Your Ref: OWPC24322
Our Ref: LU/249/19/PL
Please ask for:
Mr R Castro-Parker

Change of use of No 48 from Licenced Betting Office & Adult Gaming Centre (Sui Generis) to Retail (A1 Shops) & No 50 from Retail (A1 Shops) to Licenced Betting Office & Adult Gaming Centre (Sui Generis).
48 & 50 High Street Littlehampton

Littlehampton Town Council Planning and Transportation Committee considered this application at its meeting held on Monday 16th September 2019 and object to the proposals.

No.50 EXISTING FLOOR PLANS & SHOP FRONT | 1:100

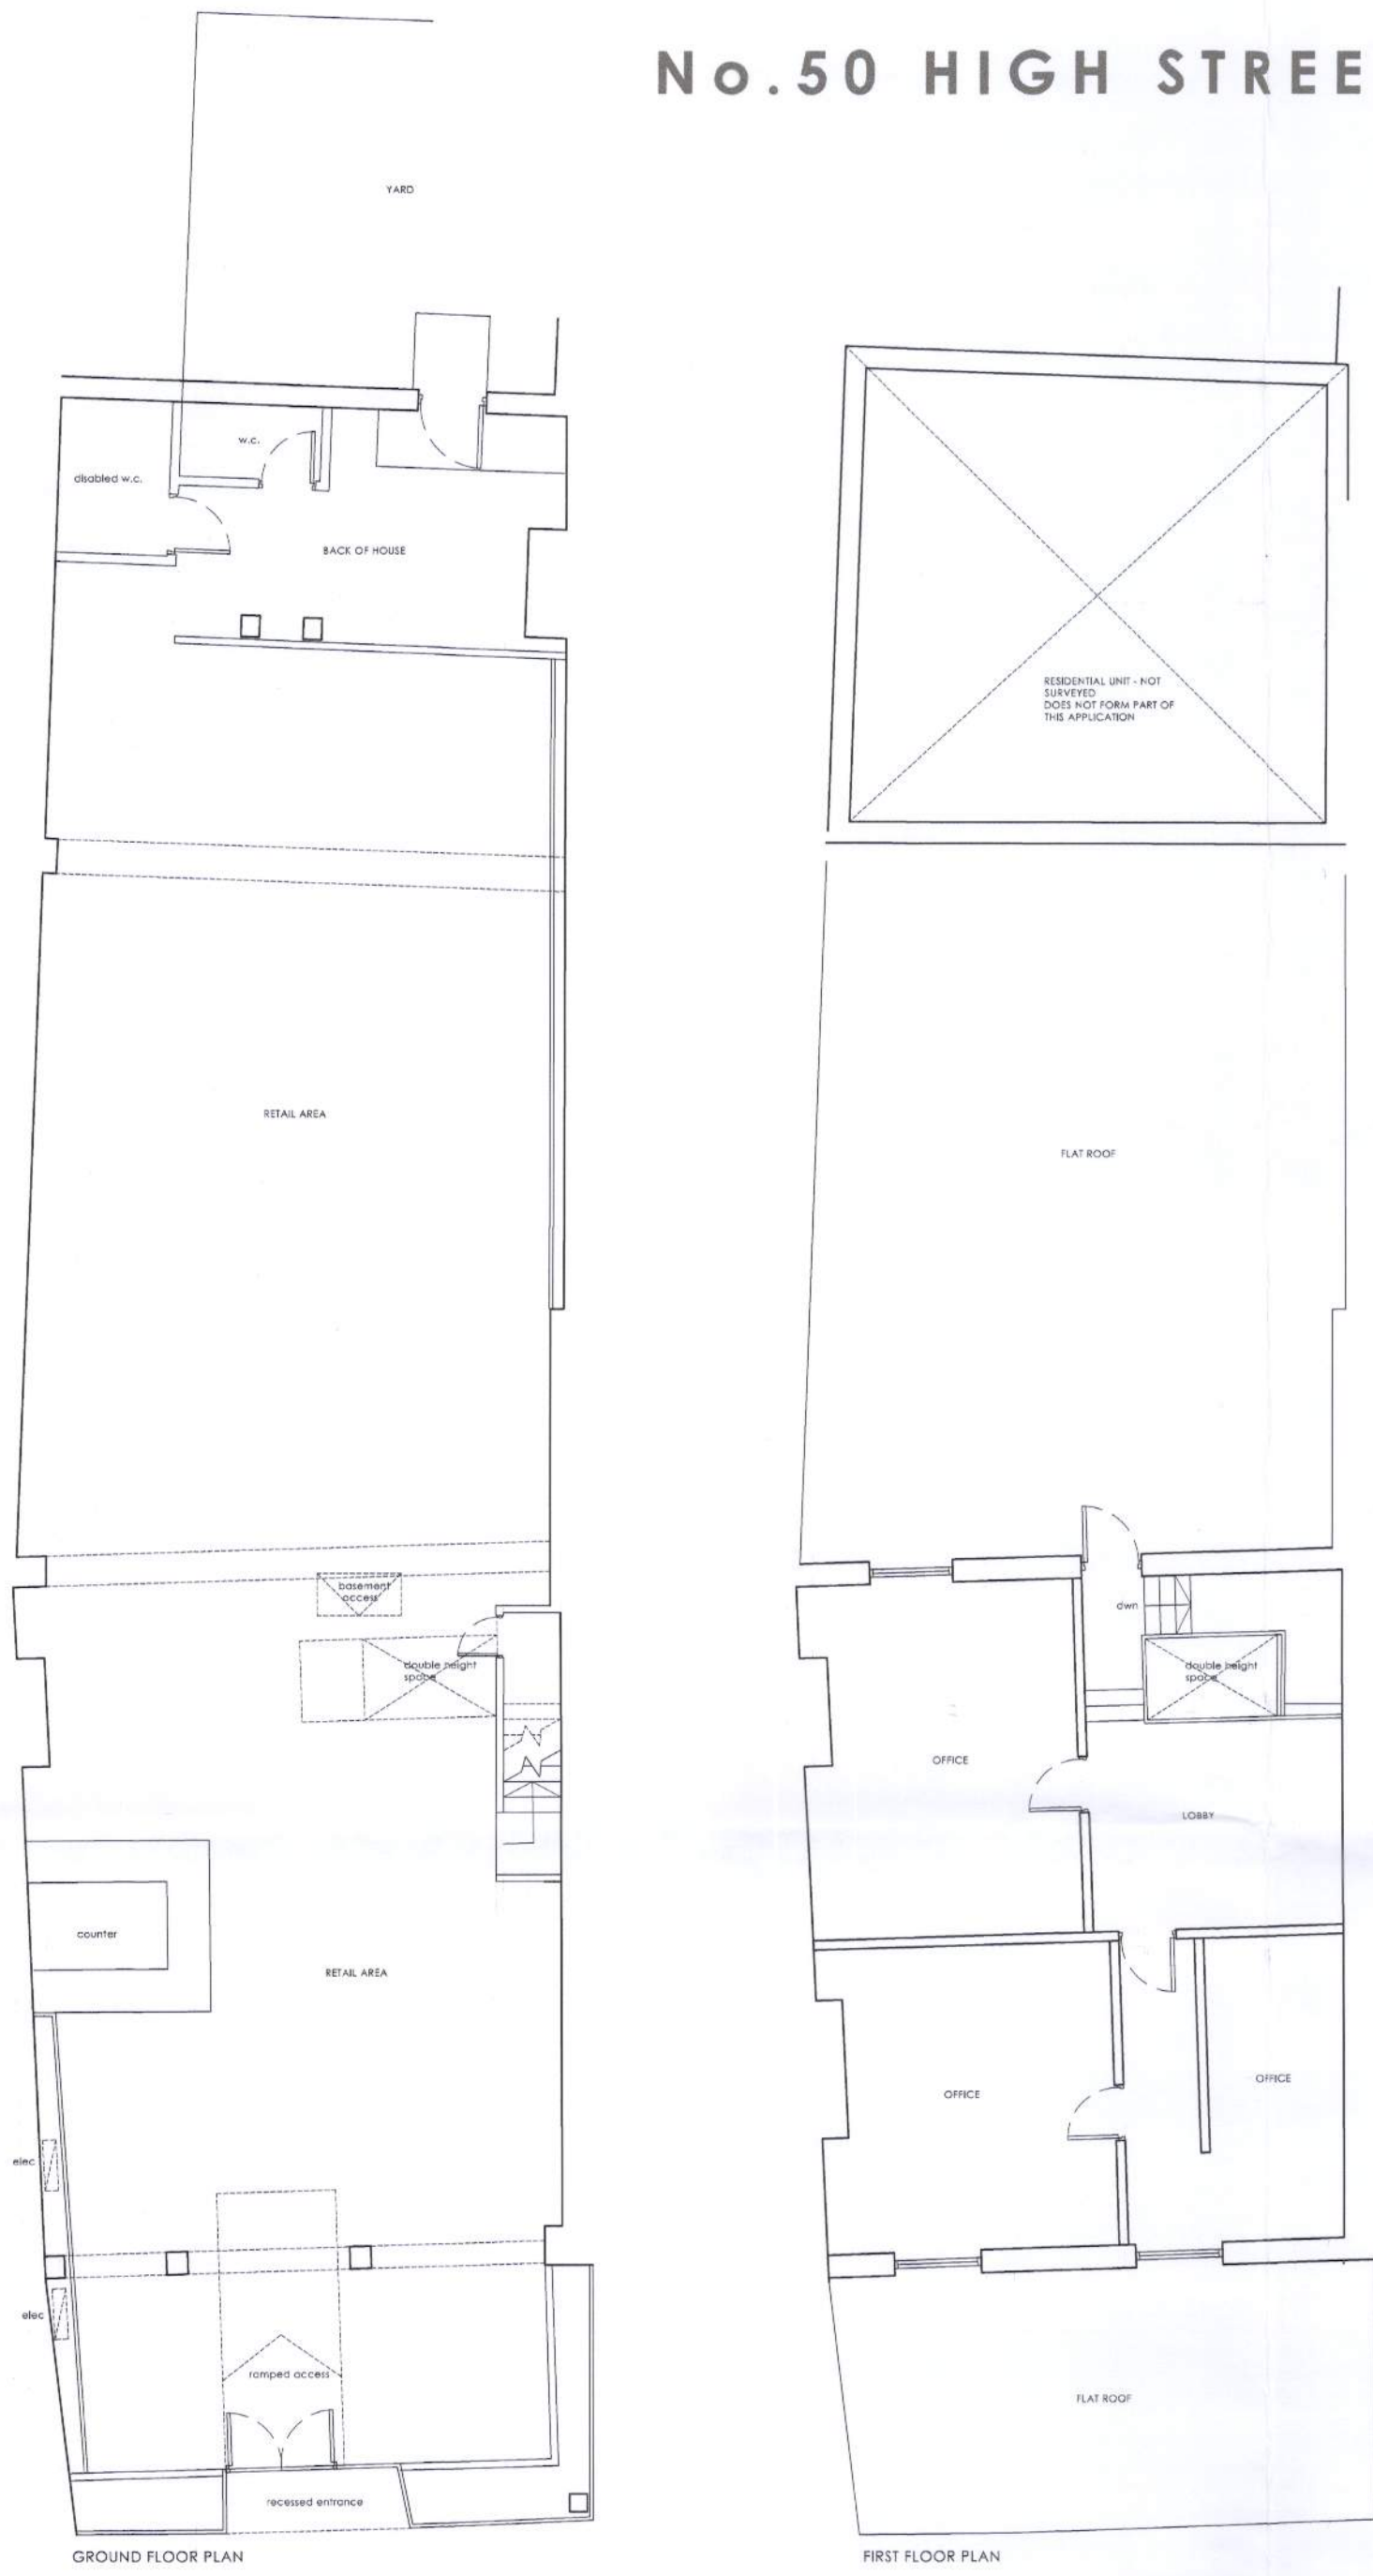
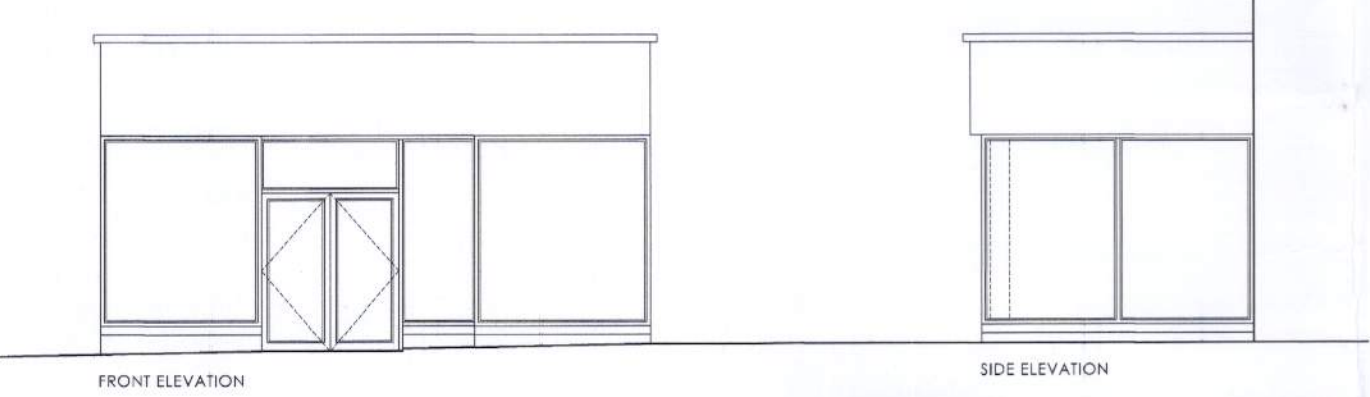
The premises at 50 High Street are designated as a building of special character under the Littlehampton Neighbourhood Plan, Policy 17. The application makes no reference to this designation or acknowledges its status which under the Arun Local Plan 2011/31, Policy HER DM2 (Locally Listed Buildings or Structures of Character) requires that 'proposals for alteration or extension will be expected to relate sensitively to the building or structure and its setting and respect its architectural, landscape or historic interest'. In this respect the relationship with the neighbouring property, number 52, also a building of special character, should be considered.

The Arun Local Plan 2011/31, Policy RET DM1 (Retail Policy) Section 2b states that 'provision should be made for a window display, appropriate to a shop front, which is in keeping with the character of the shopping area'. The plans are limited in terms of information and in particular lack details of the design of the front of the building making it impossible to judge the impact of the proposals.
